Our Ref: LU/144/19/HH

**Town & Country Planning Act 1990 (as amended)
Town & country Planning (Development Management Procedure) (England) Order 2015
Application for Planning Permission for Works or Extension to a Dwelling**

Development To remove all tile hung tiles from sides and front of property, and replace with fibre board cladding, colour to be decided but more than likely to be a grey colour

Location 62 Westlands Littlehampton

Site Plan shows area bounded by: 504372.17, 102787.28 504513.59, 102928.7 (at a scale of 1:1250), OSGridRef: TQ 444 285. The representation of a road, track or path is no evidence of a right of way. The representation of features as lines is no evidence of a property boundary.

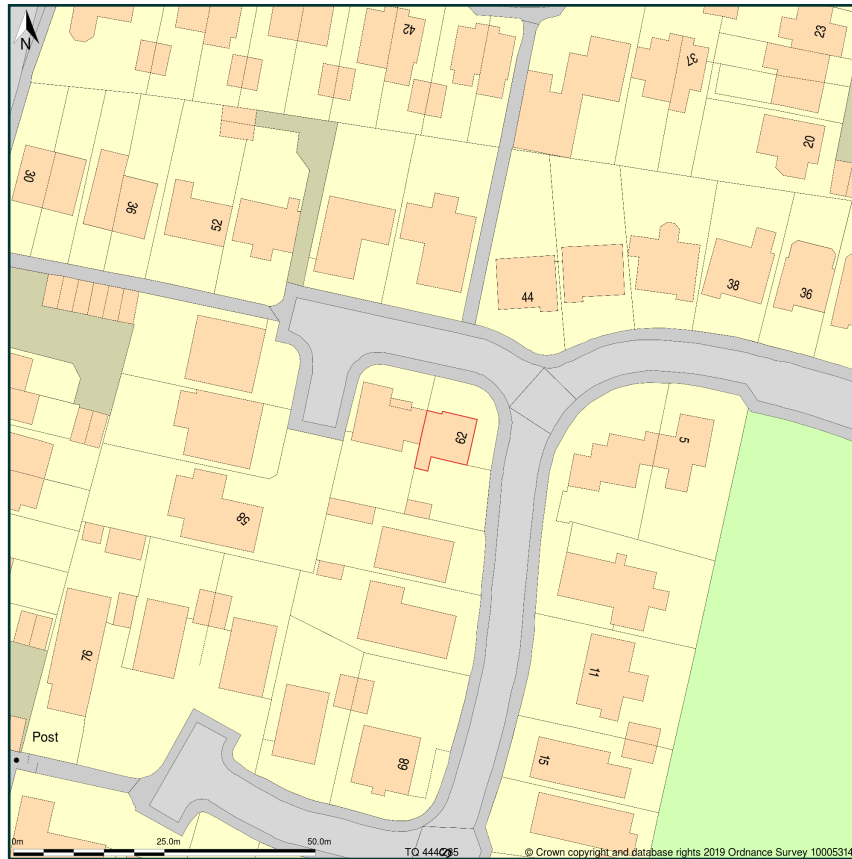
Location Plan Required: Please submit an up to date location plan. This plan should be an ordnance survey type plan at an identified standard metric scale, typically 1:1250 or 1:2500. The plan should show the site to which the application relates outlined clearly in red and should identify sufficient surrounding roads with an arrow showing the direction of north to illustrate the location. If you require assistance obtaining a location plan then you can visit the Planning Portal website (https://www.planningportal.co.uk/homepage/4/buy_a_plan) for links to where you can obtain one from;

62 Westlands
Rustington

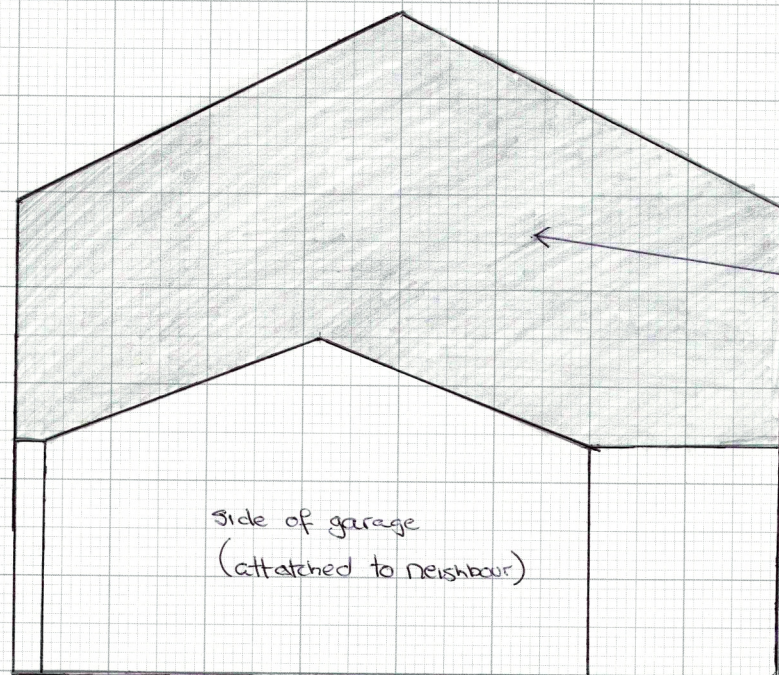
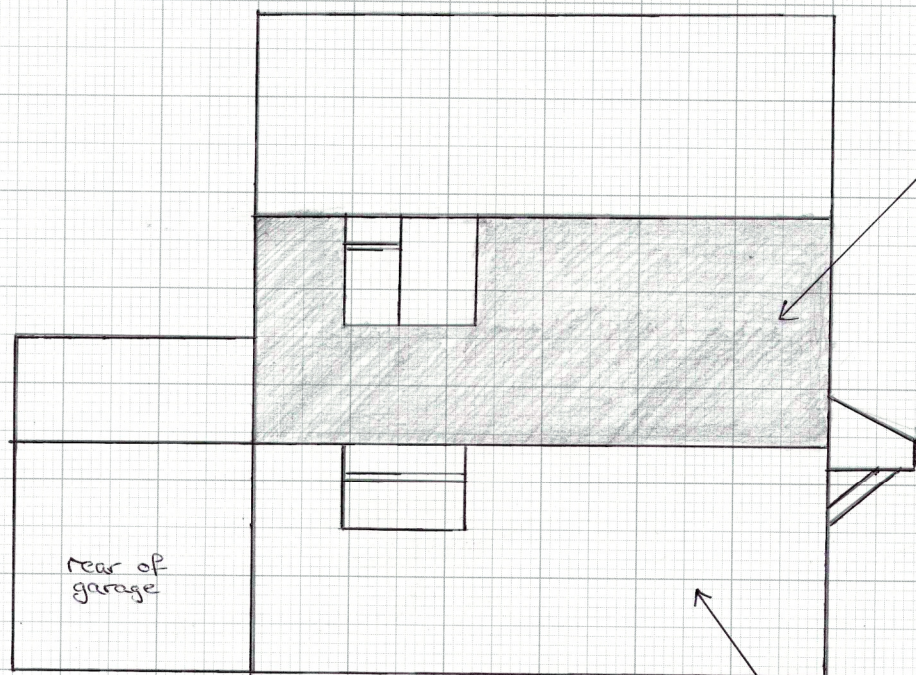
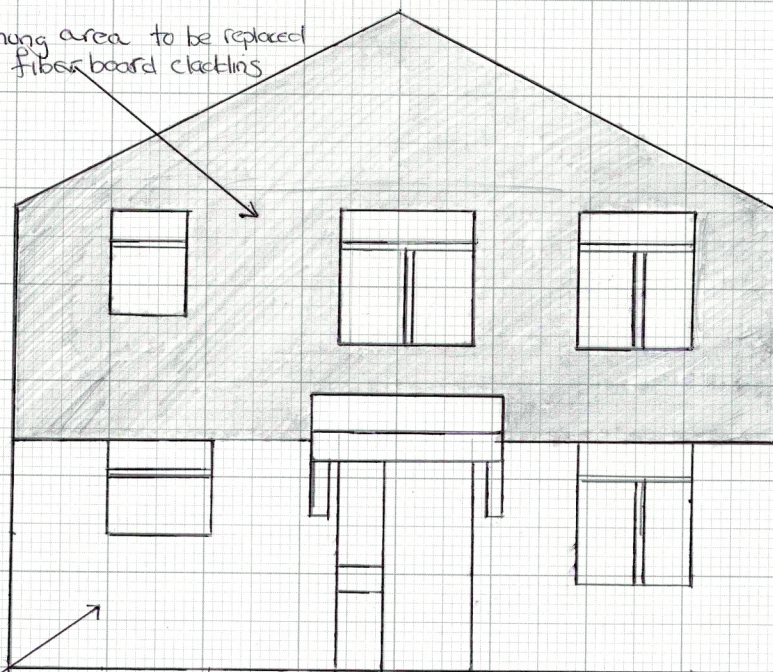
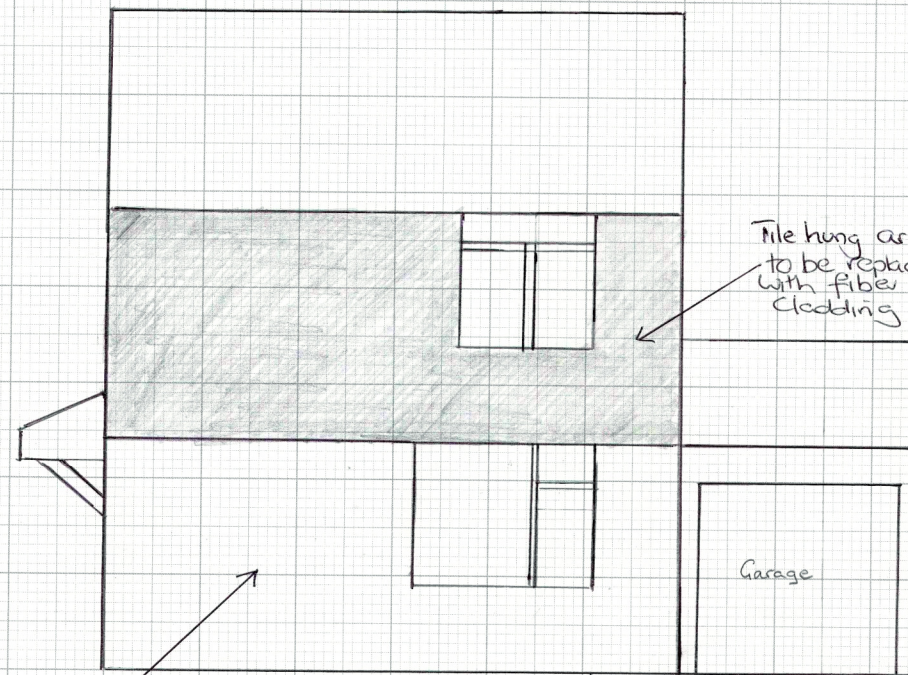
Existing Elevation: Please provide a scale on the existing elevation. This must be a standard scale such as 1:50 or 1:100 with a scale bar or dimensions to allow for confirmation of the scale.

Proposed Plan: Please provide a proposed elevation with the changes to the tiles annotated onto the plan. This must be a standard scale such as 1:50 or 1:100 with a scale bar or dimensions to allow for confirmation of the scale.
